Subject: Re: Development Control Committee 9th October 2019 - Agenda Item 7 Y/103/18/PL, 10 Acre Field, Grevatts Lane West, Yapton

Having discussed the Wilbar RSA with Paul Basham Associates, following their discussions with WSCC on the matter, it was felt there was no formal requirement for a Designer's response as they were not seeking any specific design changes to the proposal. As set out in my letter sent to Members the additional signing and tactile paving will be secured through the s278 agreement and the Stage 2 RSA. The client is happy to commit to this signing and tactile paving as set out in the RSA. This would resolve issues 01-03 in the report.

PBA drawing 128.001.007 Rev D

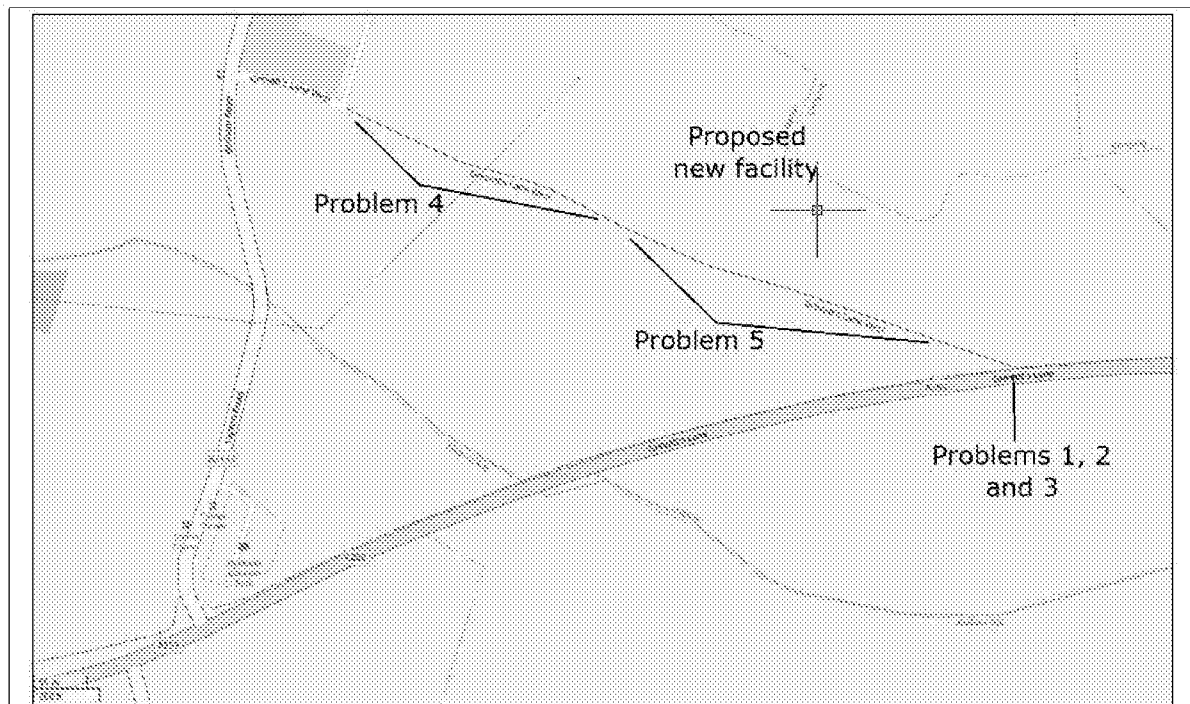
The Wilbar Report suggests in problem 04 to "*Consider the improvement of the farm track suitable for pedestrians and cyclists*". The Wilbar report is incorrect, this is not a 'farm track' but public highway, the maintenance of which is the responsibility of the highway authority. It is anticipated that 99% of users of the site will travel by car. The proposal will not generate pedestrian or vehicle movements that would justify this request.

Problem 05 suggests a "*Review the design of the track improvement and the provision of facilities for pedestrians*". Given the proposal will generate minimal pedestrian movements the provision of a footway would not be proportionate to the impact of proposal given that the existing highway provides a very low trafficked safe shared route. Wilbar Associates may not have understood the very low level of pedestrian activity proposed.

I can also confirm that the tracking of an HGV (previously provided) would allow for all vehicle movements including coaches. It is not anticipated that coaches would use the facility given the size and capacity of the facility.
